RE: Project File Number, Brown and Jackson, SE-20-00003

Our written comments submitted are in regard to Washington State Environmental Policy Act (SEPA), Chapter 43.21C RCW, and Kittitas County Grading Permit public notice Brown and Jackson, SE-20-00003, dated, Monday, August 17, 2020. It is of our understanding that Kittitas County is acting as SEPA Lead Agency for the proposed project and proposed SEPA project actions and that Kittitas County is reviewing Brown and Jackson's June 11, 2020 Kittitas County, Department of Public Works, Grading Permit Application. However, based on review of the documents we understand we are commenting on the project as a whole, including, but not limited to, Washington State Department of Ecology's General Permit for Biosolids Management.

**SHEET NO.**  
**1 of 2**  
 201834

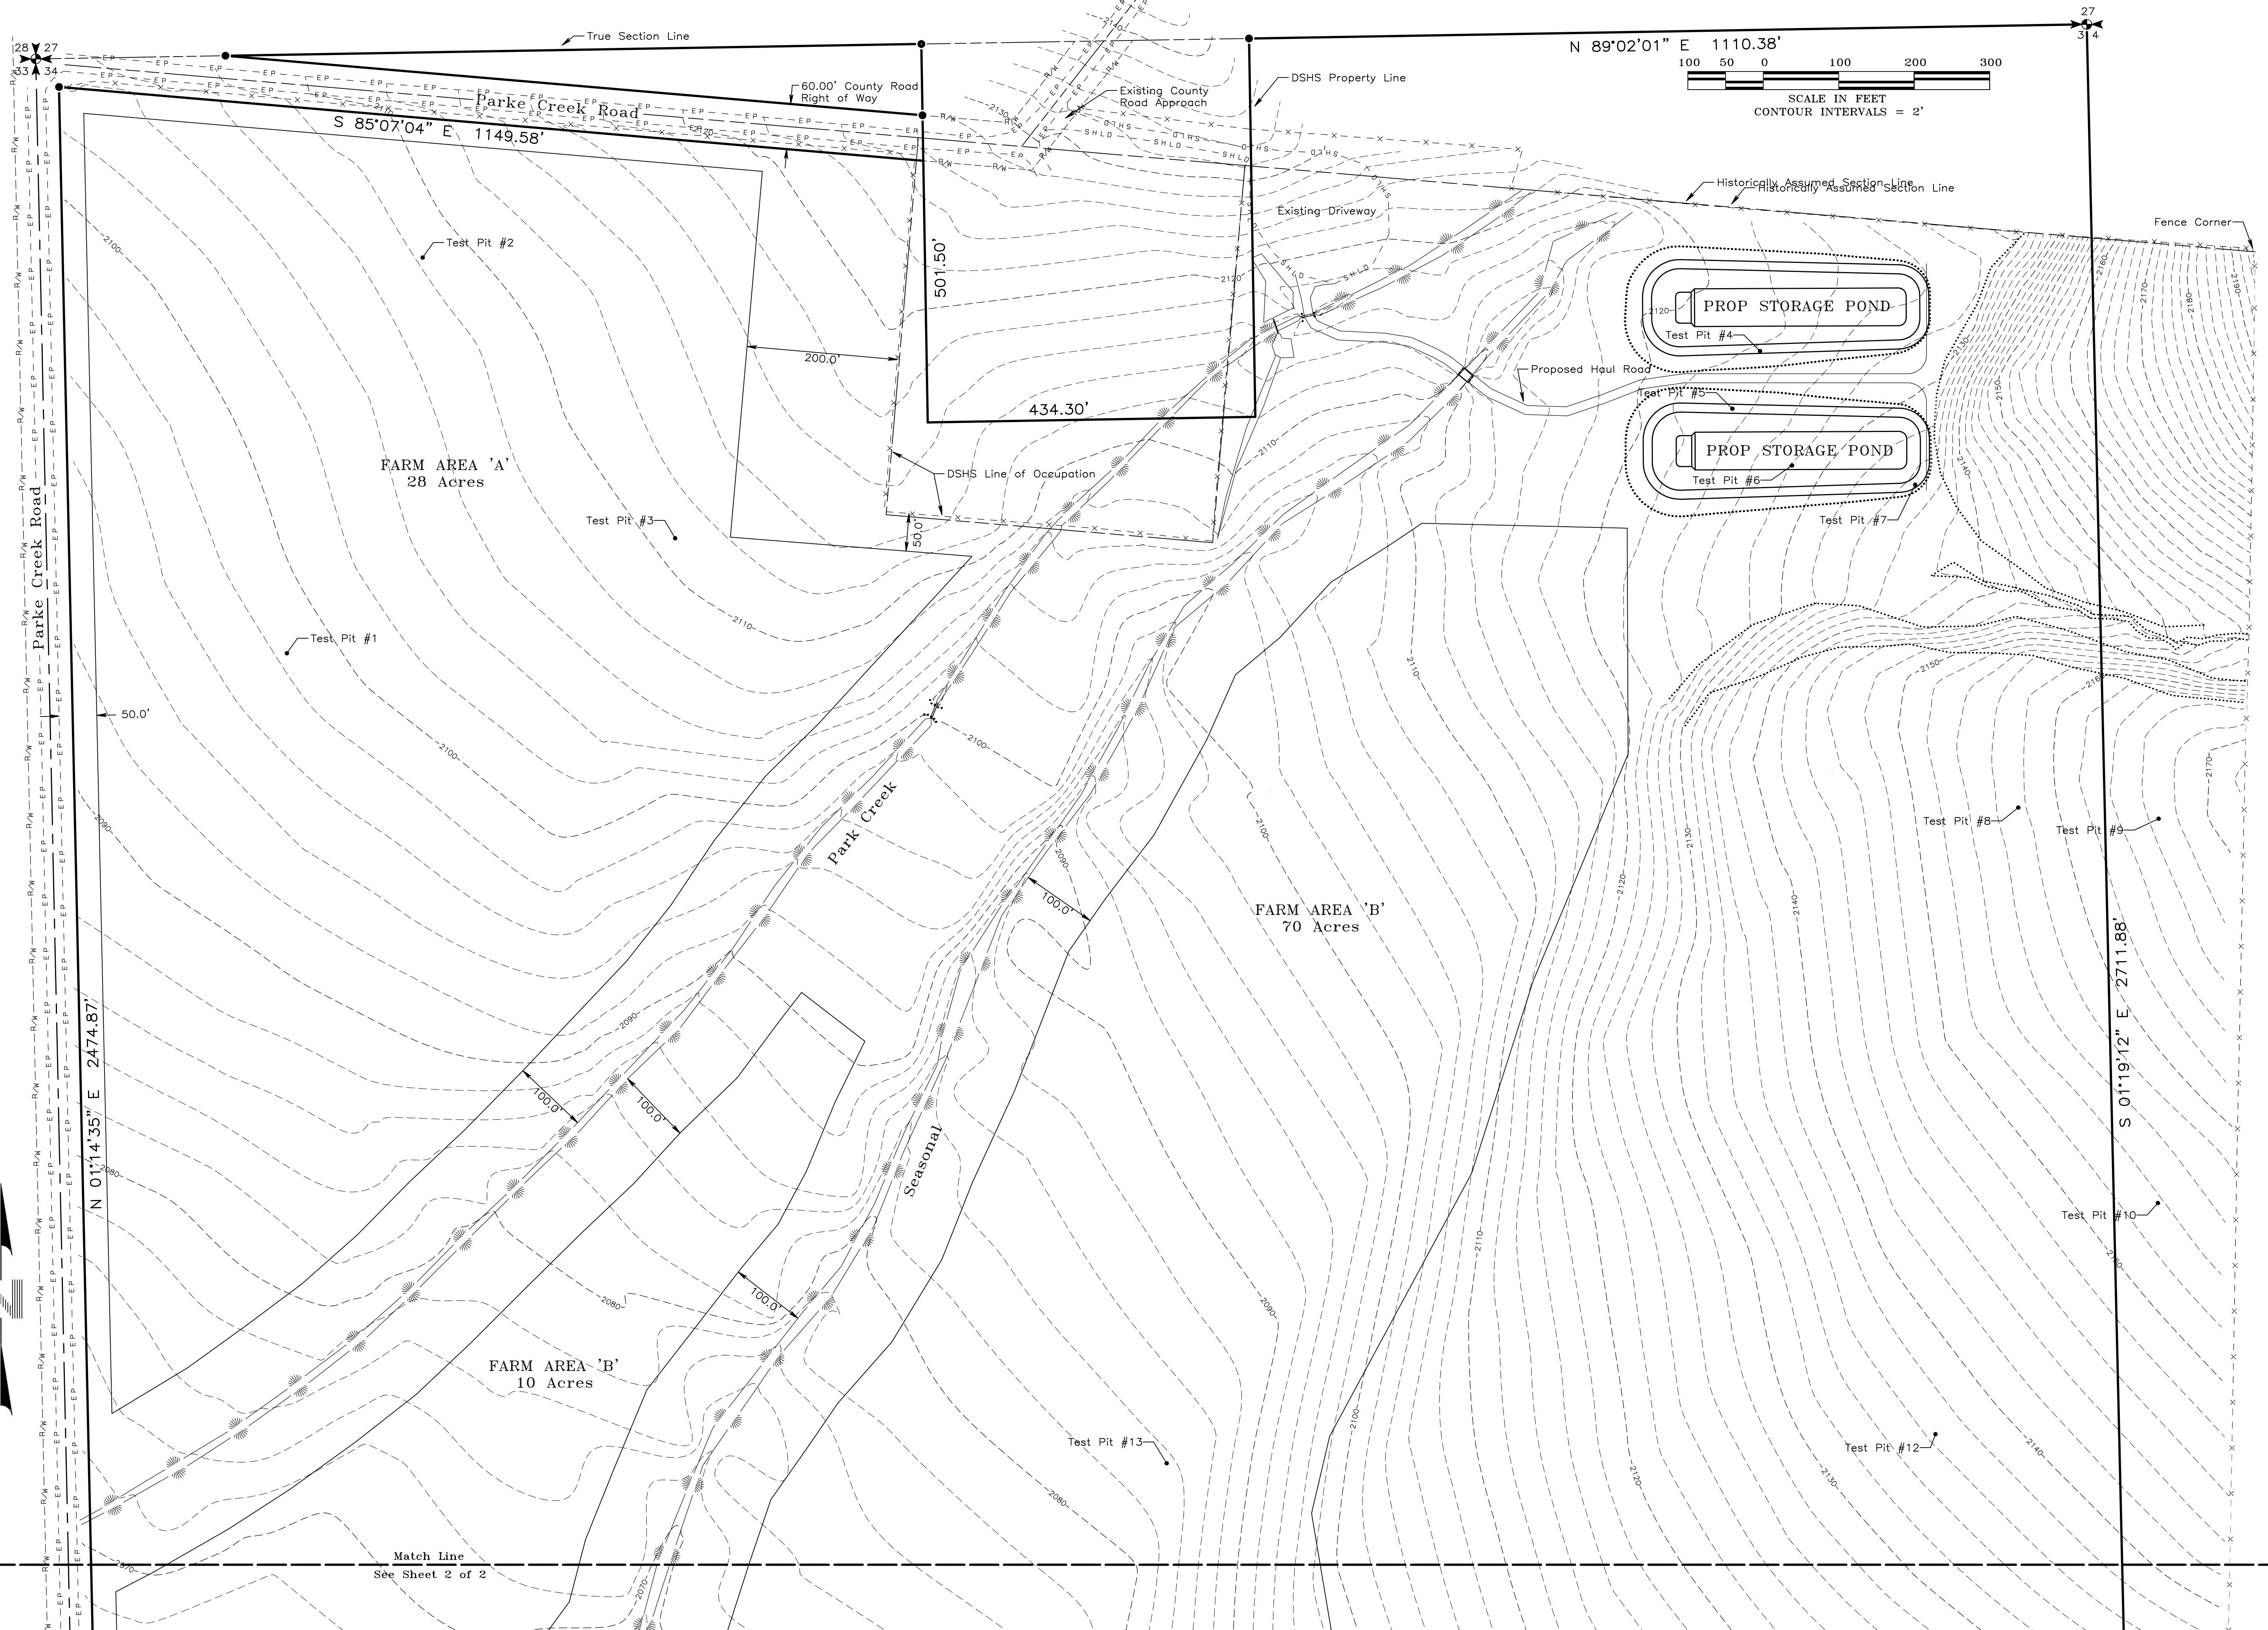
A.12.: Included Preliminary Site Plan does not appear to locate features, such as streams and irrigation ditches accurately. Included map in the July 30, 2020 Western Pacific Engineering and Survey document improperly characterizes Parke Creek's location with respect to the fields and proposed storage ponds. Parke Creek is the water body flowing from the north to south on the eastern-center portion of the site. The irrigation ditch, locally known as Parke Creek Ditch, flows from the east to the west across the site conveying irrigation and stock water to farms and ranches several miles downstream of the site. Please update maps and labeling.

A.1.: Parke Creek Ditch flows east to west diagonally across the project site. Parke Creek flows north to south across the project site. KRD North Branch Canal immediately abuts the project site to the south. 3 surface water bodies, total. Please update.

B.1. Answer provided is incorrect. The Parke Creek Ditch and KRD South Branch Canal are either within or immediately adjacent to the project. Describe how any runoff or over application of septage will directly impact 1,000's of acres of highly valuable farmland and crops.
